**From:**  
**Sent:** 19 September 2023 20:48  
**To:** Victor Grayson  
**Subject:** 2023/92255,2023/92327,2023/92254,2023/92253

**Comments in relation to the following applications by Newett Homes:**

**2023/92255** Land at Green Acres Close, Emley, Variation of Conditions 1 (Plans) , 2 (Crime Prevention) and 15 (Permitted Development) of Previous reserved matters approval 2021/93286 pursuant to outline permission 2020/91215

**2023/92255 and 2023/92327 – Plan modifications**

Overall Site Plan (1:1000)

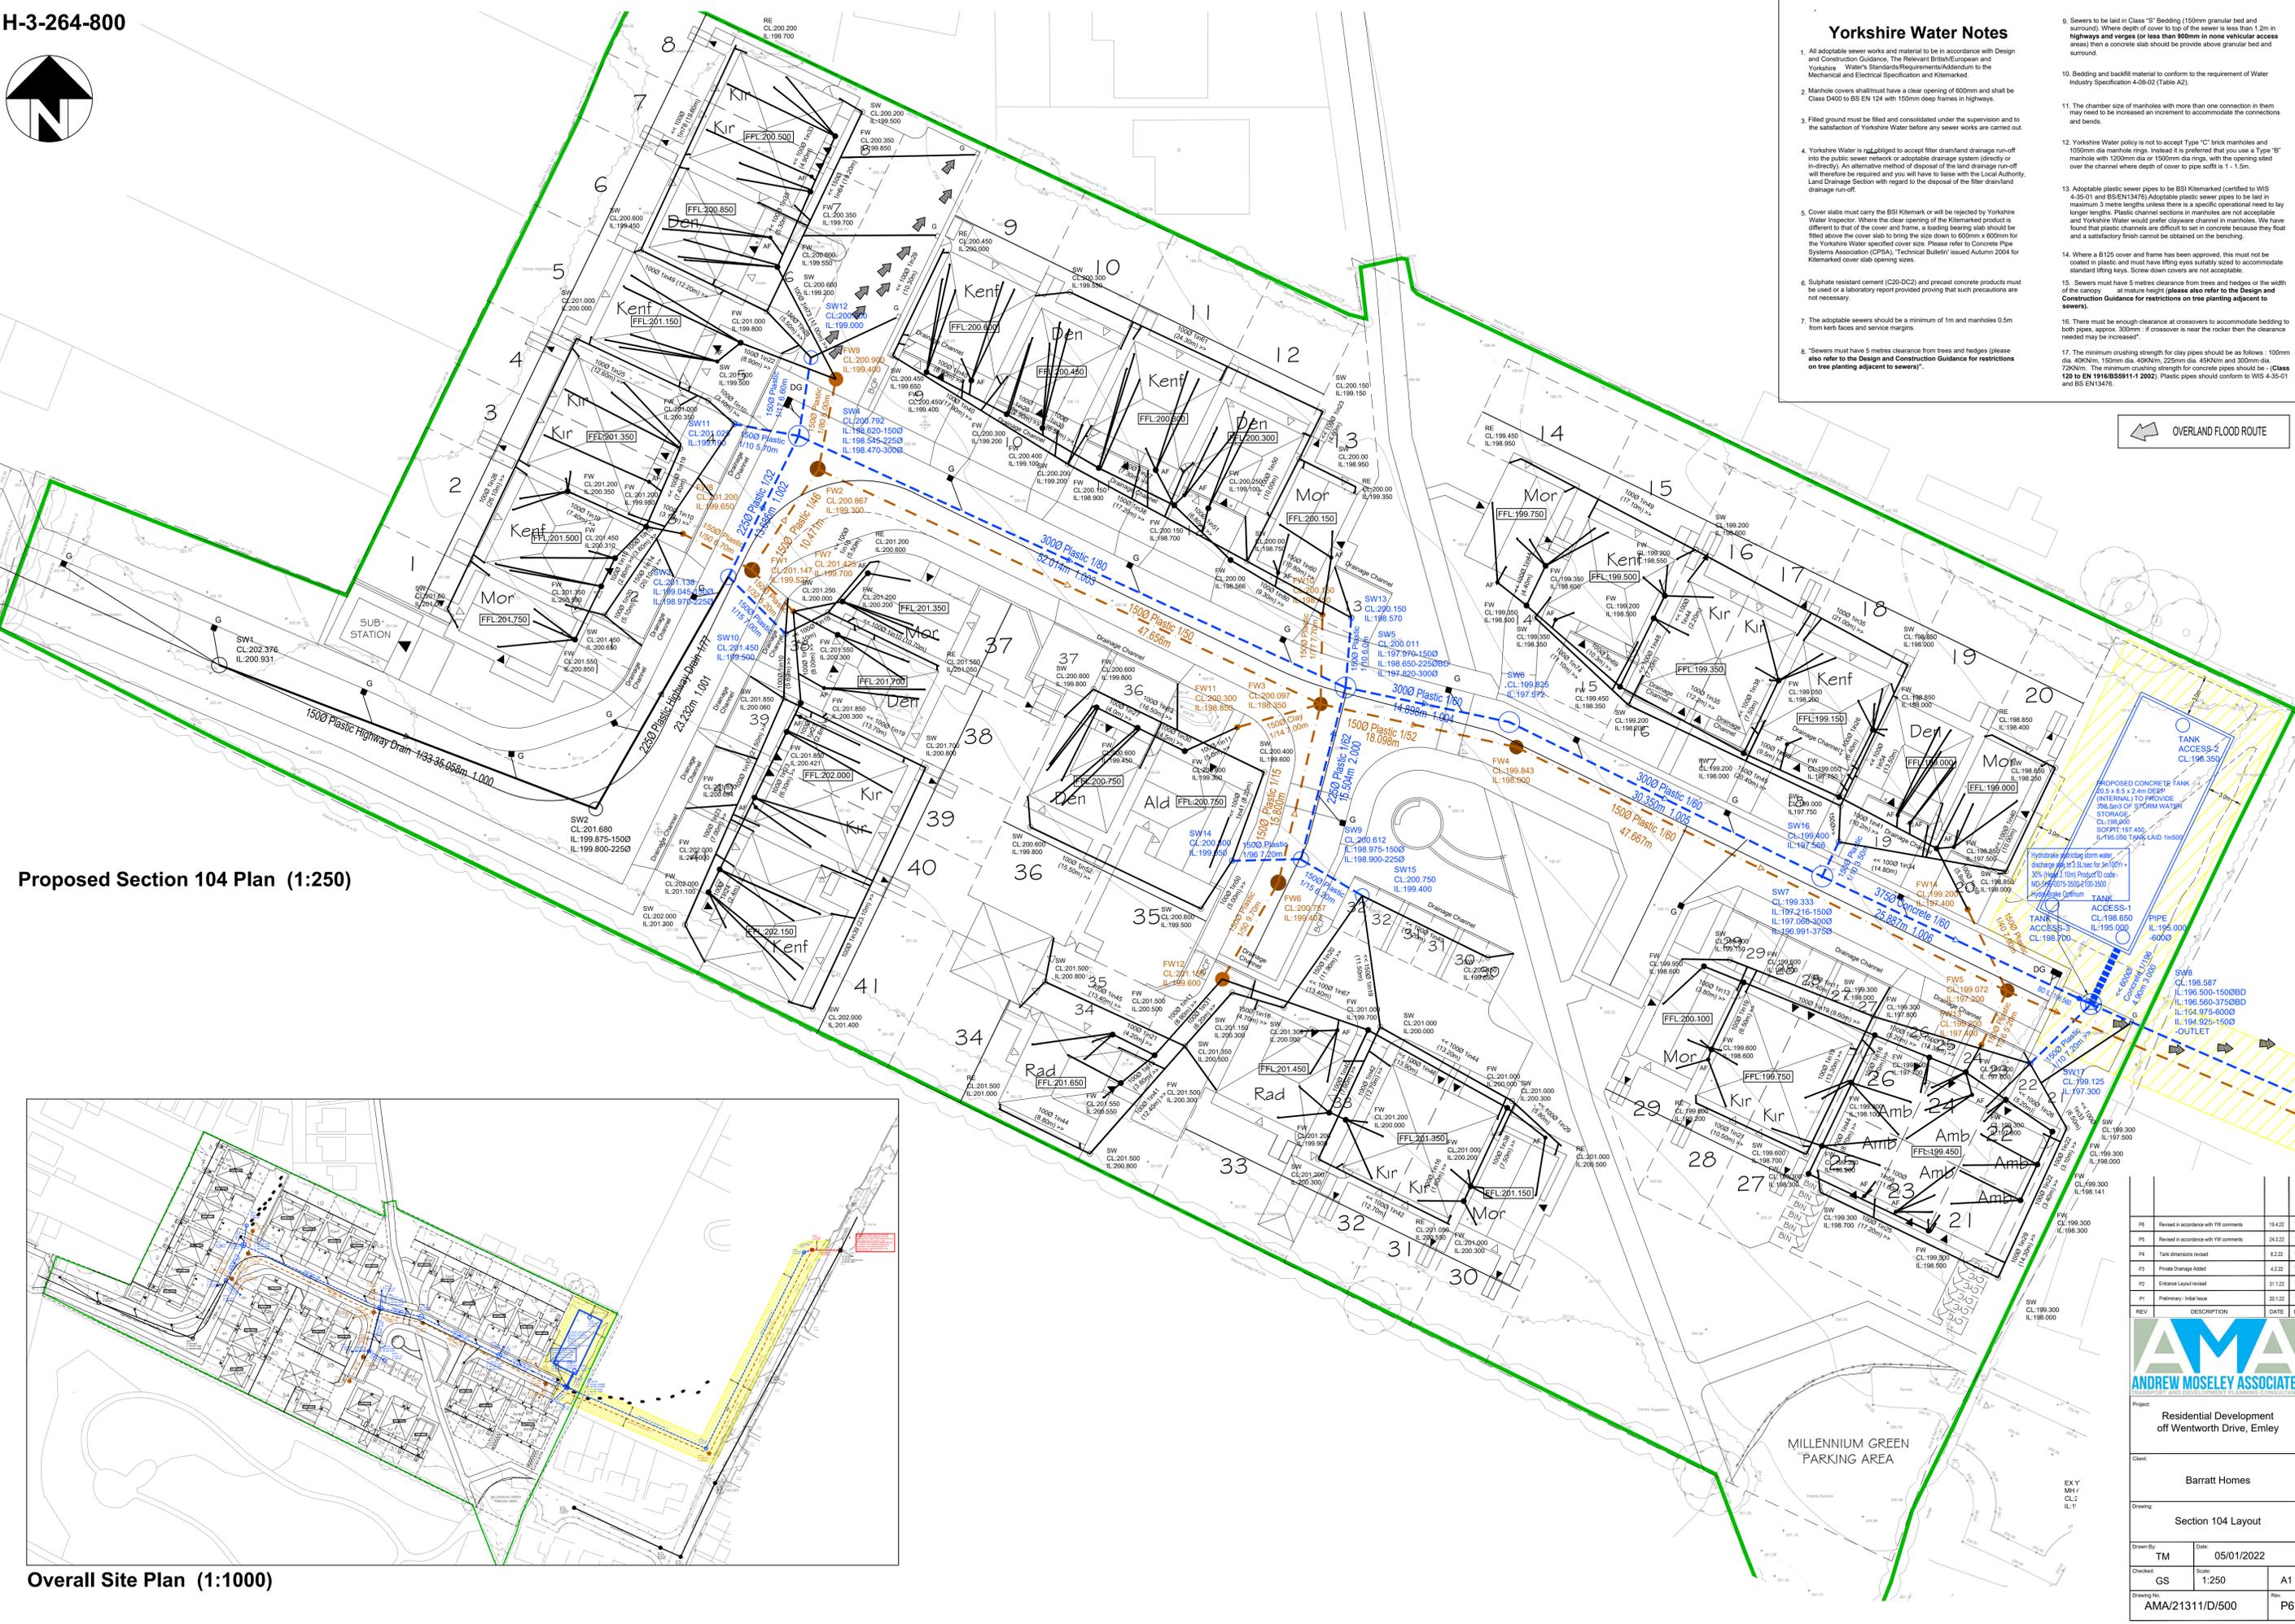
Newett Homes have submitted plans for temporary drainage that will affect the parking area and entrance to the Emley Millennium Green – Any drainage plans that affect the parking area or entrance must be discussed and agreed with the Trustees of the Green and must not block or impede the area at any time.
